**Planning Department
Transportation Development Services**

**Re: Dreamstyle Warehouse
1525 Renaissance Blvd NE
Traffic Circulation Layout
Engineer's/Architect's Stamp dated 5-12-15 (F16-D051A)**

SITE PLAN

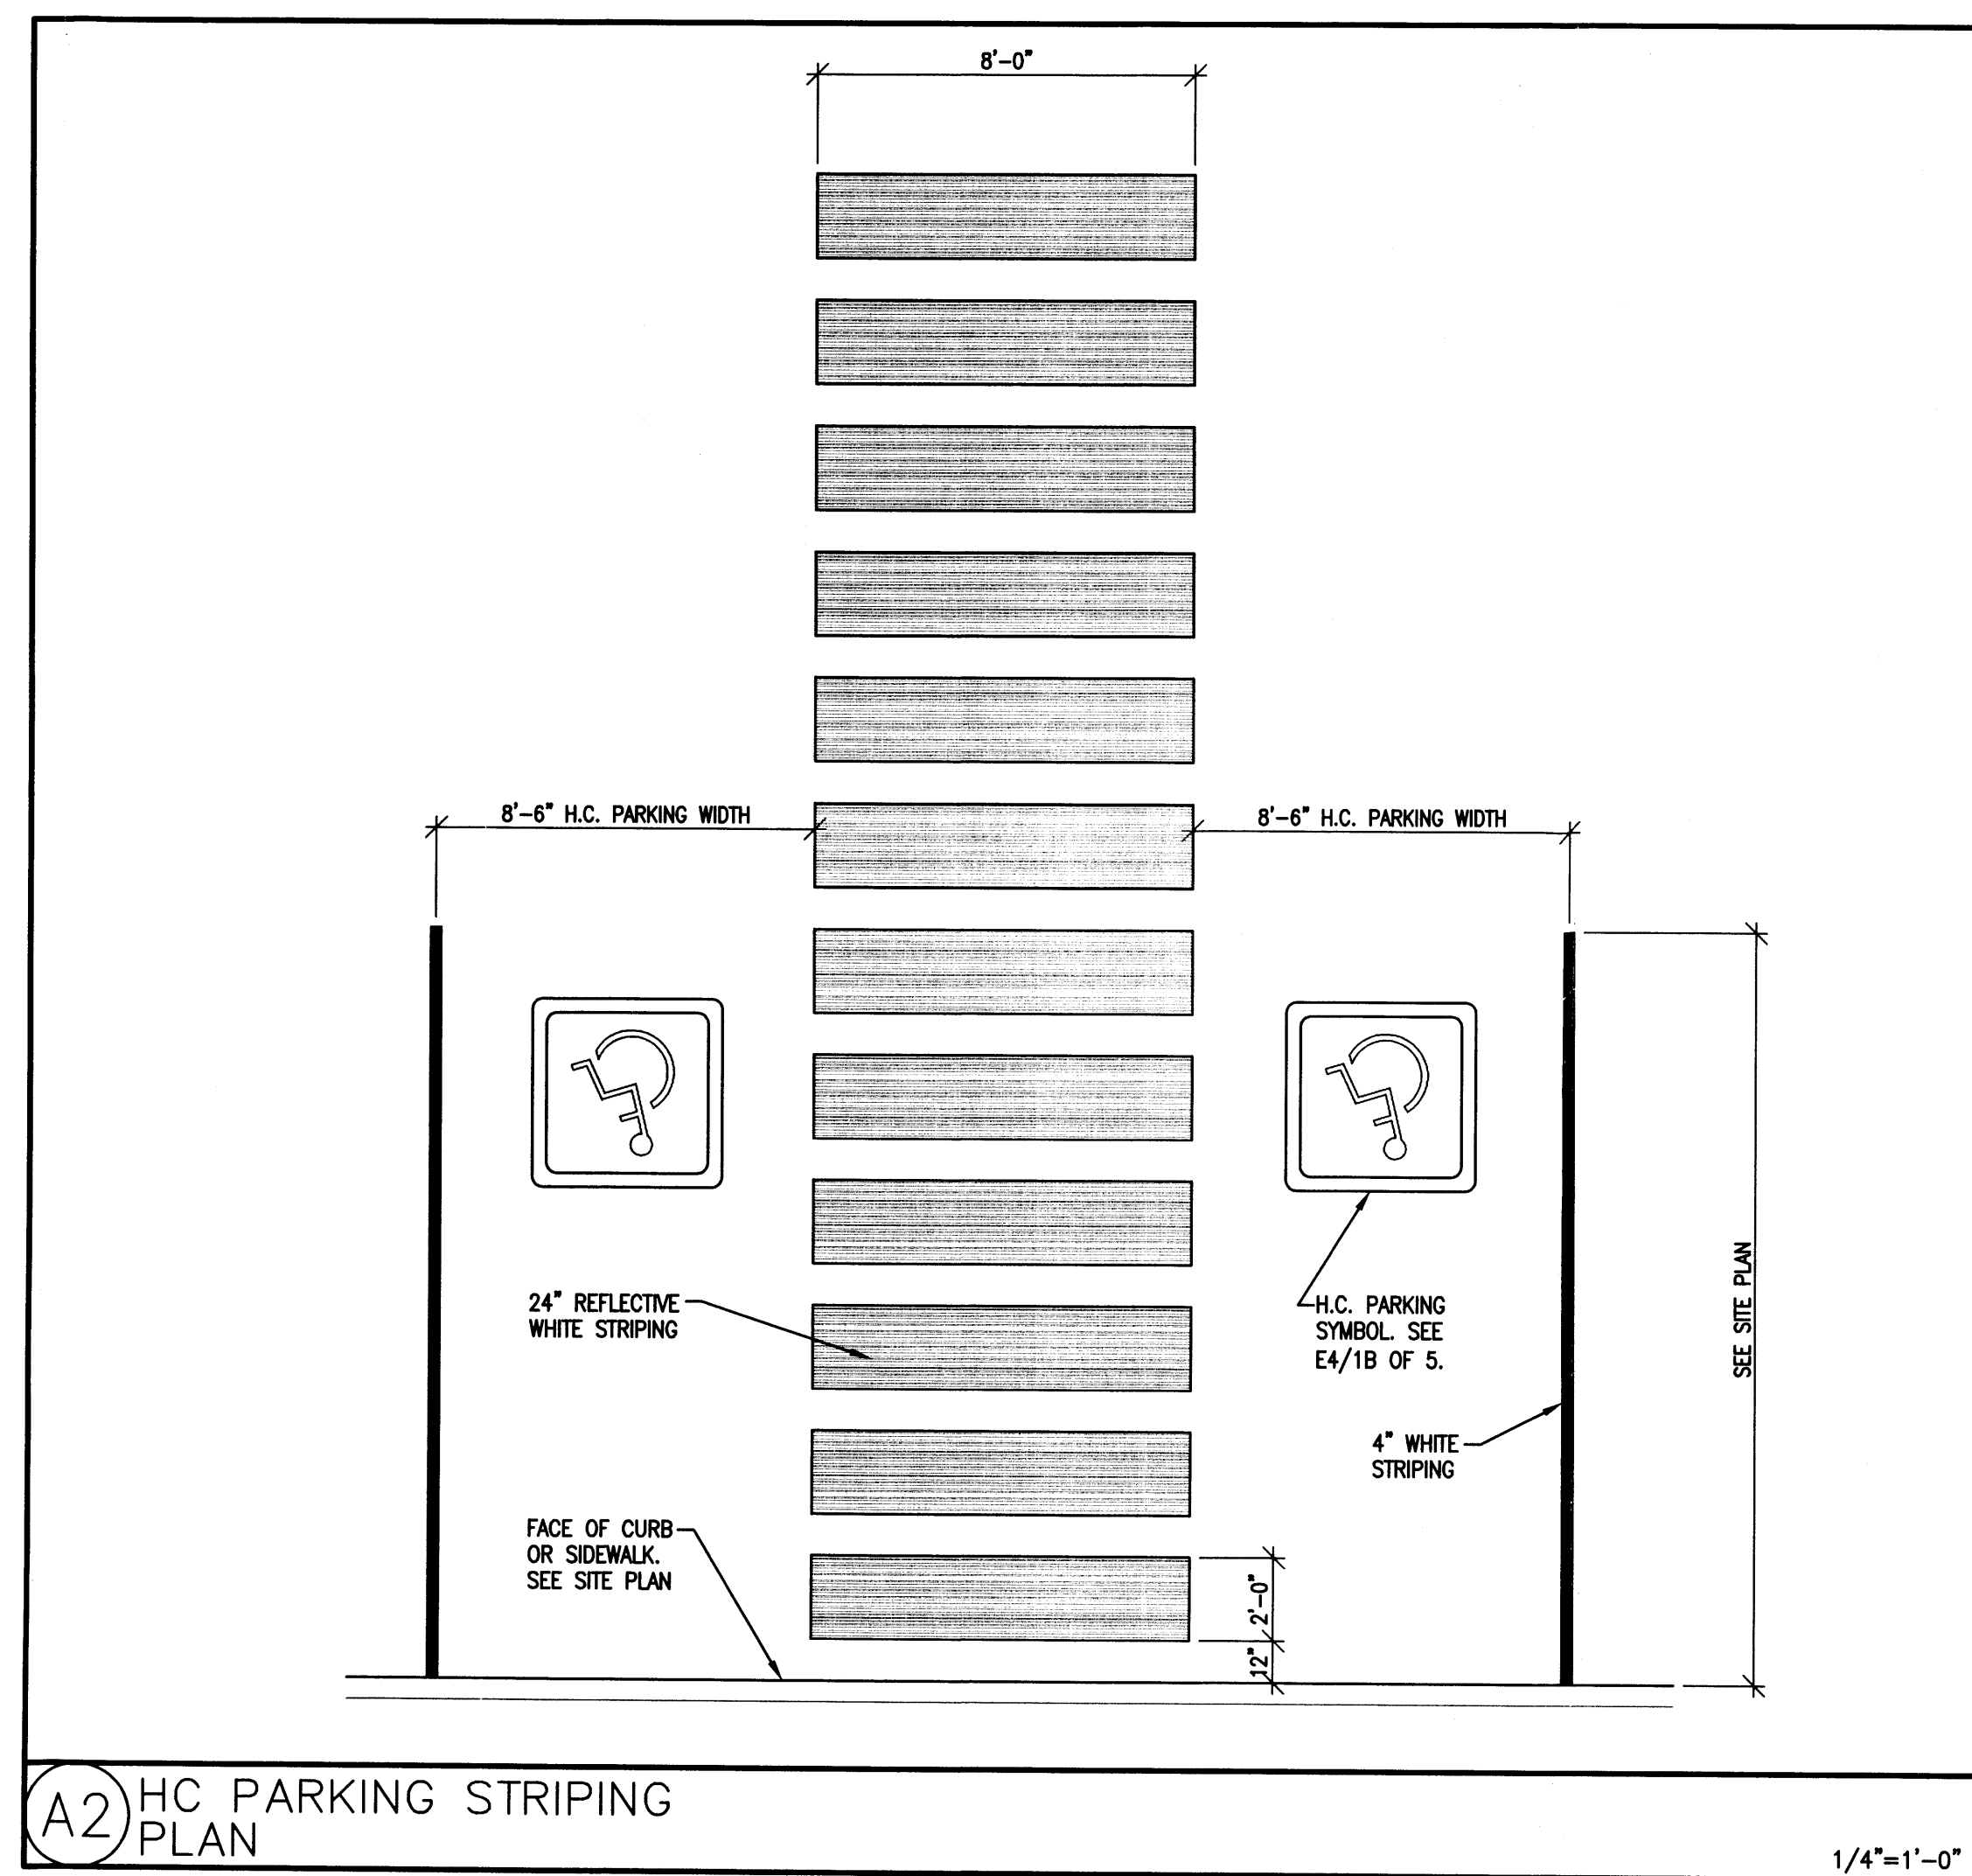
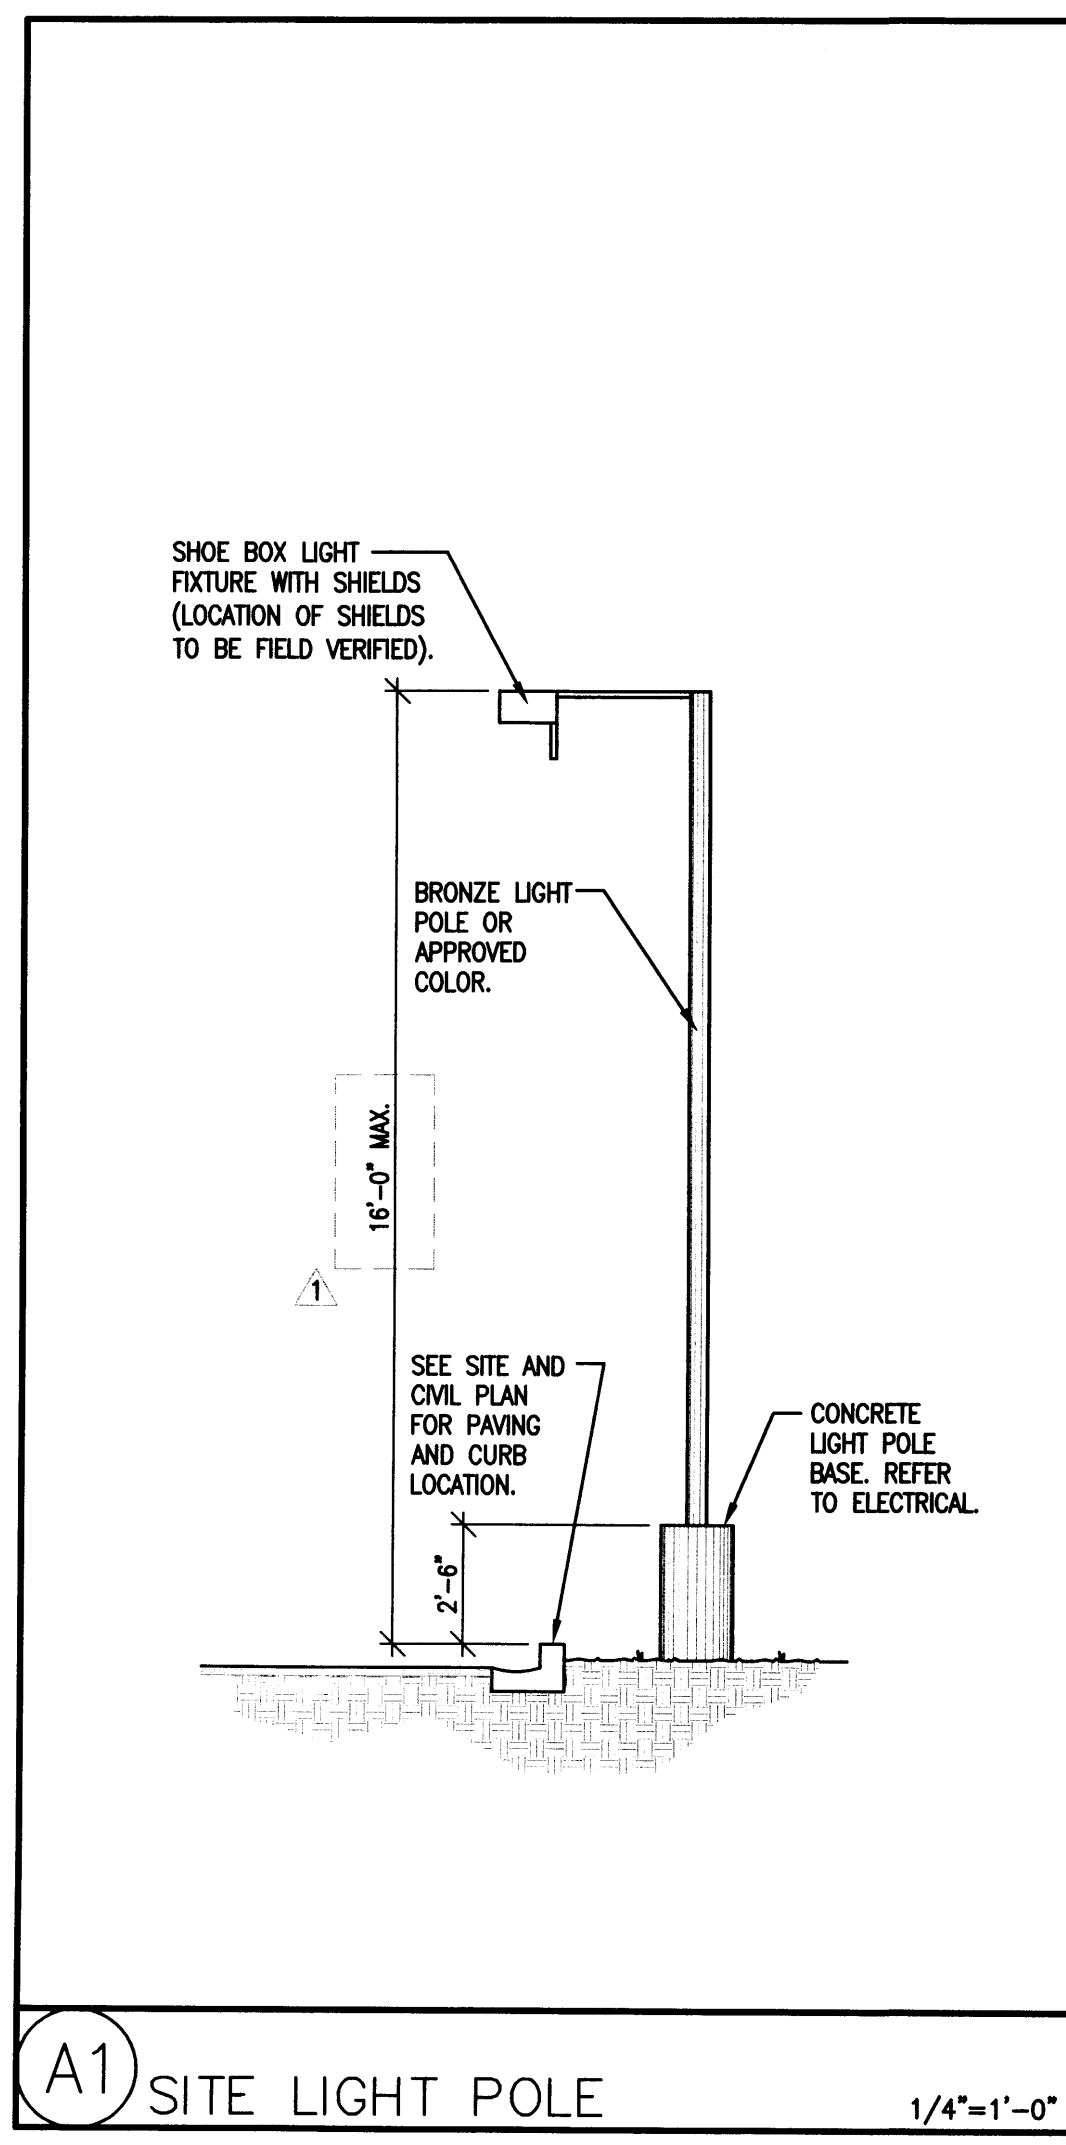
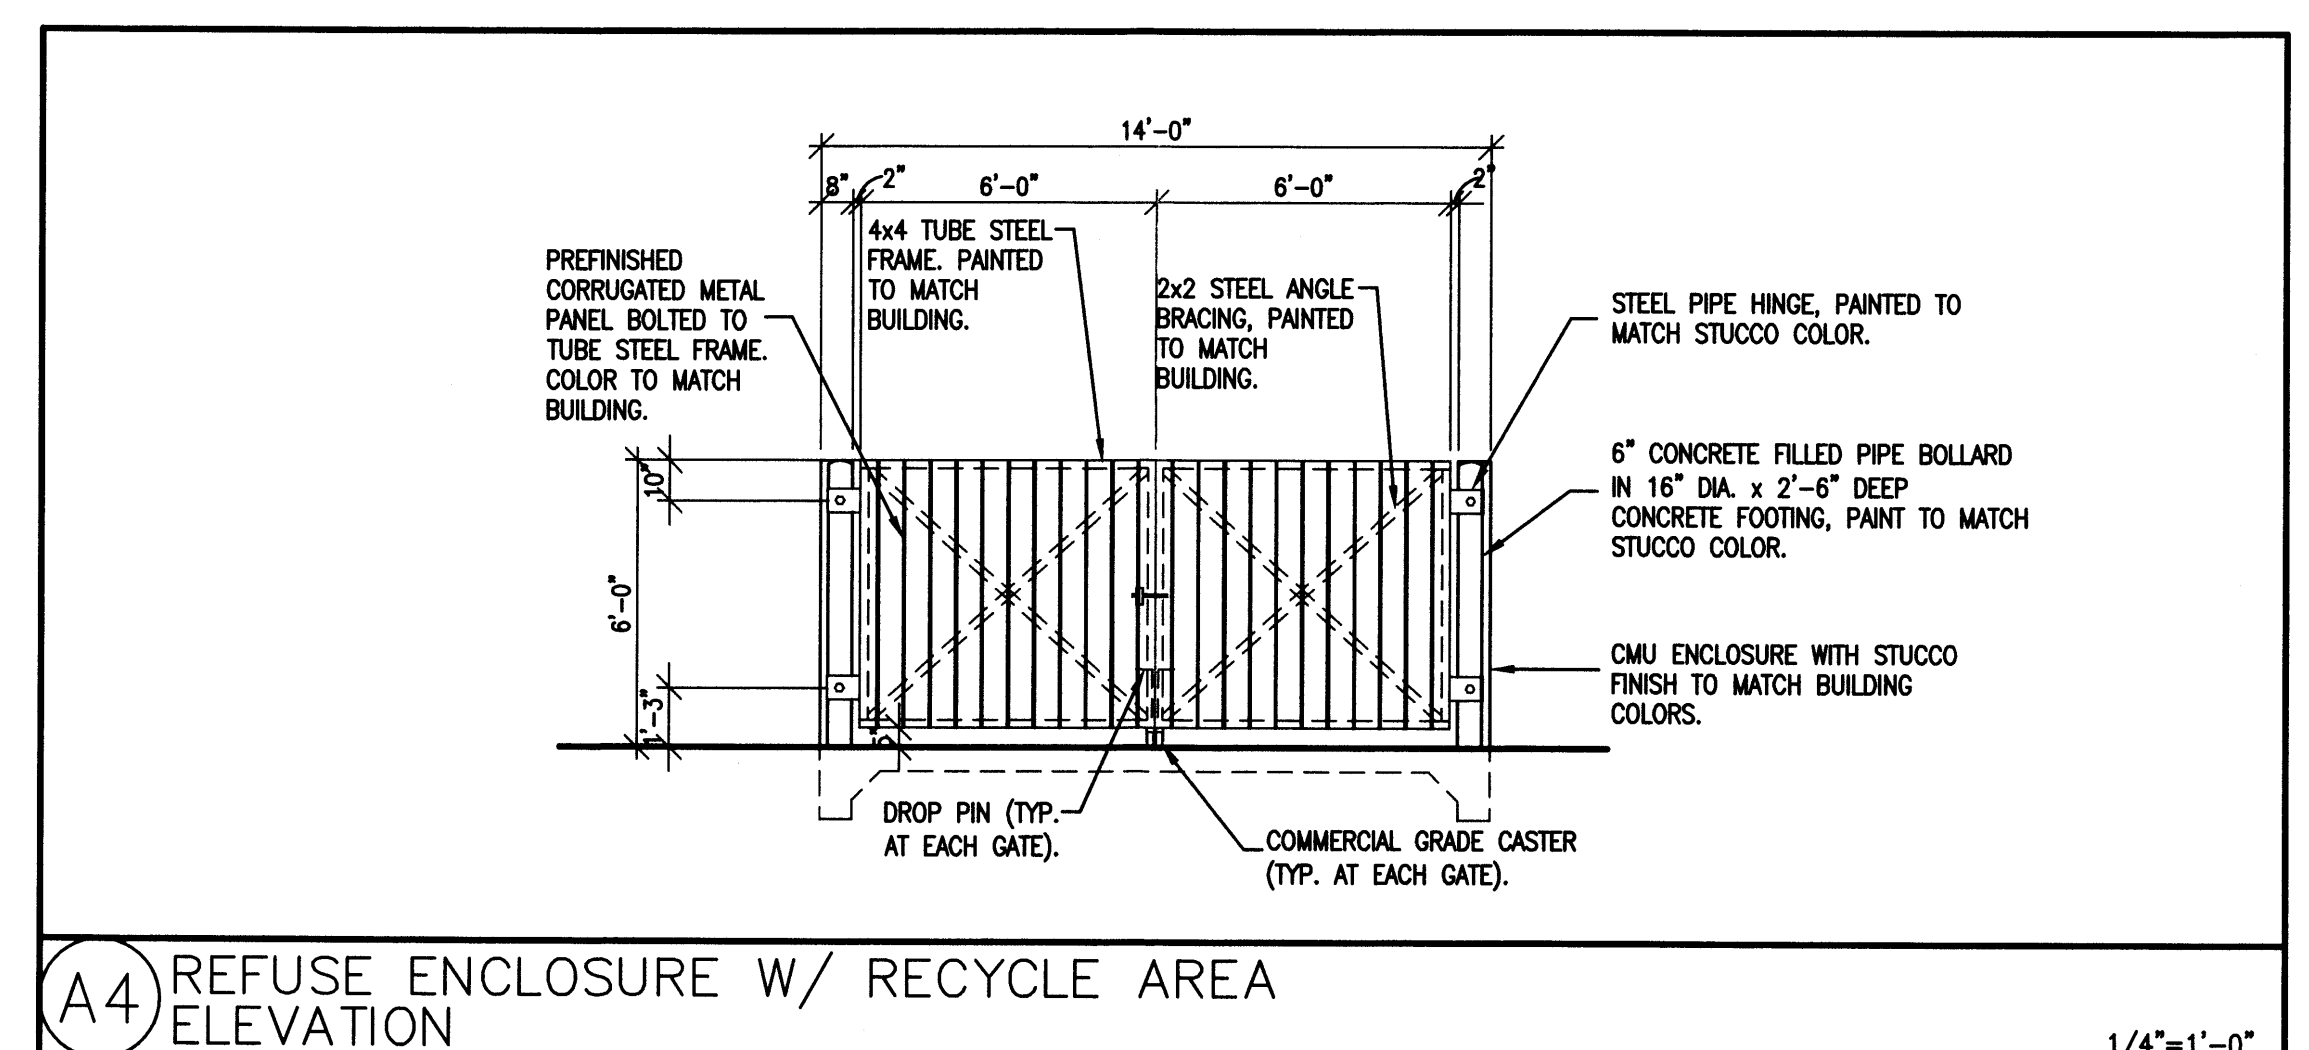
1. Identify and dimension the right of way width, medians, curb cuts and street widths on Renaissance Blvd.
2. Label the compact parking spaces by placing the words "**COMPACT**" on the pavement of each space. Only 30% of the required parking spaces are allowed to be compact designated, revise as necessary.

3. Please identify and detail the bicycle rack.
4. The handicap accessible spaces must be a minimum of 8.5 feet in width.
5. The handicap accessible spaces must include an 8-foot wide van access aisle; all other aisles should be 5 feet in width.

6. The ADA van accessible sign must have the required language per 66-7-352.4C NMSA 1978 "**Violators Are Subject to a Fine and/or Towing.**"
7. The ADA access aisle shall have the words "**NO PARKING**" in capital letters, each of which shall be at least one foot high and at least two inches wide, placed at the rear of the parking space so as to be close to where an adjacent vehicle's rear tire would be placed. (66-1-4.1.B NMSA 1978)

8. Please detail the Private Entrance off of Renaissance Blvd, per COA Standard Drawing No. 2426. Detail ADA ramps with truncated domes from public sidewalk to pedestrian walkway entrance to proposed building.

9. Per the DPM, a 6 ft. wide ADA accessible pedestrian pathway is required from the public sidewalk to the building entrances. Please clearly show this pathway and provide details of walkway and 6 ft. ADA landing at top of the ramp.
10. Design delivery vehicle route needs to be shown.
11. Service vehicle and/or refuse vehicle maneuvering must be contained on-site; provide a copy of refuse approval (if applicable). Detail Refuse truck route.
12. It is not apparent what type of pavement surface is being proposed. A hard driving surface will be required as part of this proposed project for parking area and drive aisles.
13. Please provide a sight distance exhibit for entrance from Renaissance Blvd. (see the *Development Process Manual, Chapter 23, Section 3, Part D.5 Intersection Sight Distance*).

14. Please add the following note to the clear sight triangle: "Landscaping and signage will not interfere with clear sight requirements. Therefore, signs, walls, trees, and shrubbery between 3 and 8 feet tall (as measured from the gutter pan) will not be acceptable in this area."
15. Provide the address of the proposed building on the Site Plan.
16. Please add the Vicinity Map and Zone Atlas Map number on the Site Plan itself.
17. Please include two copies of the traffic circulation layout at the next submittal.
